RE: Response to Submissions SSD 7372 MOD 5 – O'Connell Street Public School

Attachment A – Response to Submissions Table

Table 1 **Response to Submissions**

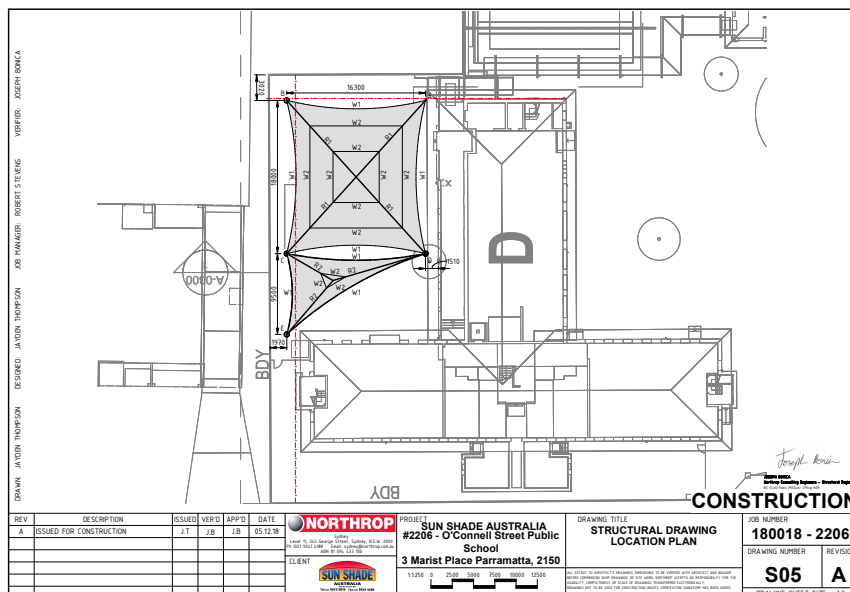
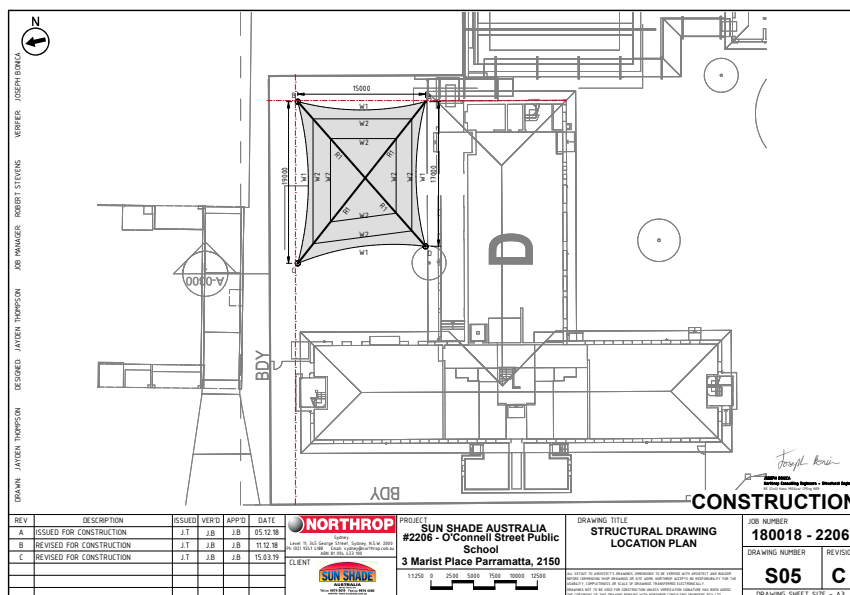
<i>The size of the shade structures is to be reduced so that they do not extend further north than Building D.</i>	<p>Whilst both TZG Heritage and City of Parramatta Council are of the opinion that the shading structure is largely not visible from the public domain, the shading structure design has been revised to mitigate any potential heritage impacts and enable compliance with OEH's request to align the shading structure to the northern building line of Building D.</p> <p>In order to modify the design to comply with OEH's recommendation, the secondary triangular structure has been deleted as it cannot conform to</p>

Issue	Response
	<p>the revised design. This presents a reduction of approximately 22% of shaded area within the playground and alters the location of footing B and C to be more central within the playground. Any further reduction to the shade sail size would render the purpose of the shade structure ineffective.</p>
<p><i>Request arborist input to assess the integrity of the TPZ and root system of the existing Frangipani Tree in relation to the proposed shading structure footings.</i></p>	<p>Arborist input was sought to assess the integrity of the existing Frangipani Tree, and its relationship with the proposed shading structure. The report sets out recommendations to ensure the health of the tree is maintained and monitored over the course of the design and construction phases.</p> <p>The report concludes that the proposed shade sail may impact the Frangipani Tree canopy and root system. The height of the structure is 3.5 metres and footing D of the shading structure is 100mm in diameter. As the structure will enter the TPZ at 2.5 metres on the north eastern side, the tree will still be able to absorb solar gain from the northern and the western sides. At 3.5 metres, the tree canopy is likely to be impacted, but the structure is located outside the structural root zone, maintaining the health of the root system.</p> <p>As a result of the shade structure, the Frangipani Tree is likely to experience direct solar loss, as the tree requires high levels of sunlight. However, the arborist is of the opinion that the shading structure will reflect light from the top of its surface, increasing solar gain to the tree. The arborist concludes that this is a suitable approach in order to maintain the health of the tree.</p> <p>The report recommends that the roots of the tree should remain intact, and that the footings of the shade structure should have a clearance of 200mm to any major root or canopy branch. The design of the shading structure has been revised slightly to accommodate this recommendation.</p>

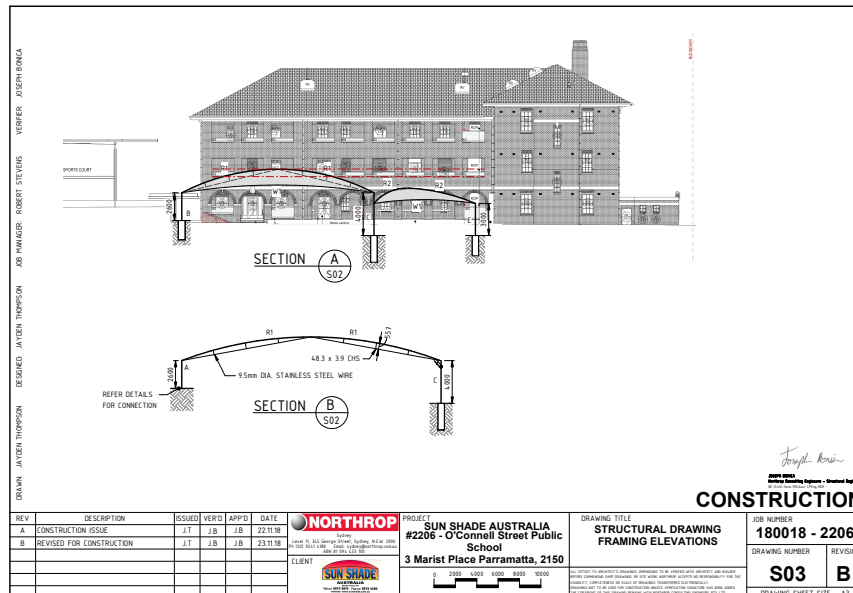
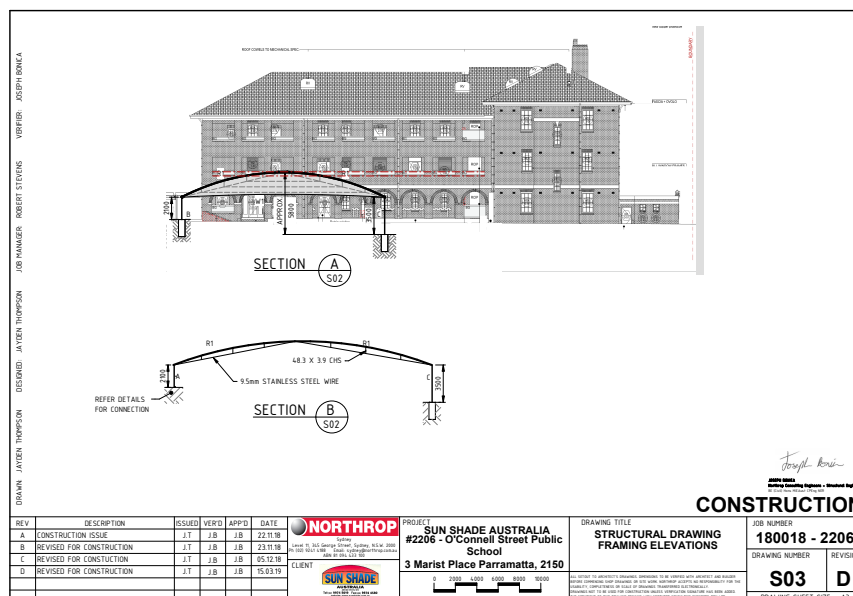
Issue	Response
<i>The large shade sail is to be reduced in height to sit below the first-floor openings. Consideration should be given to a flatter sail design which corresponds more closely to the height of the triangular sail.</i>	<p>The design of the shading structure has been revised to reduce the height of the shade sail by 700mm. Whilst this is still higher than the first floor openings of Building D, the shading structure cannot be reduced further in this location due to the elevated ground height at the eastern end of the playground, where the structure has a height of 2100mm from existing ground level. 2100mm is the minimum recommended height contained in Part 3.8.2 Vol 2 of the Building Code of Australia.</p> <p>It is important that the height of the revised shading structure remains at 2100mm, as any further reduction in height breaches both the BCA recommendations, as stated above, and could provide opportunities for vandalism and intrusion into the property. This is due to the topography of this part of the site, and the shading structure's location adjacent to the site boundary. The site is bound by a retaining wall and fence, which could potentially enable intruders to climb onto the shading structure and enter into the school grounds. If the shade sail is lowered further, this may present an opportunity for intruders to scale the fence and enter the premises. Principles established through Crime Prevention Through Environmental Design (CPTED) reiterate the importance of 'target hardening' to prevent opportunities for criminal activity. 'Target hardening' in this instance is ensured by the height of the proposed shading structure, which limits climbing opportunities for potential offenders.</p> <p>Lastly, whilst the shade sail has been redesigned to accommodate OEH's concerns as far as possible, a flatter sail cannot be accommodated due to the manufactured composition of the sail fabric. The sail fabric has a density which enables high UV protection to the occupants of the playground. Due to the dense nature of the sail fabric, the overall structure must be designed to ensure that efficient water run off solutions are incorporated into the design in order to prevent fabric damage, which may diminish the effectiveness of the sail for sun protection. If the sail structure is designed to be flat, intense rainfall may result in water pooling which can cause the sail fabric to stretch and sag from the weight of the water, damaging the structure and rendering it ineffective.</p> <p>Additional heritage advice was sought from TZG Heritage which supports the revised design and its relationship with Building D and the wider site. Refer to Appendix B submitted with this submission.</p>
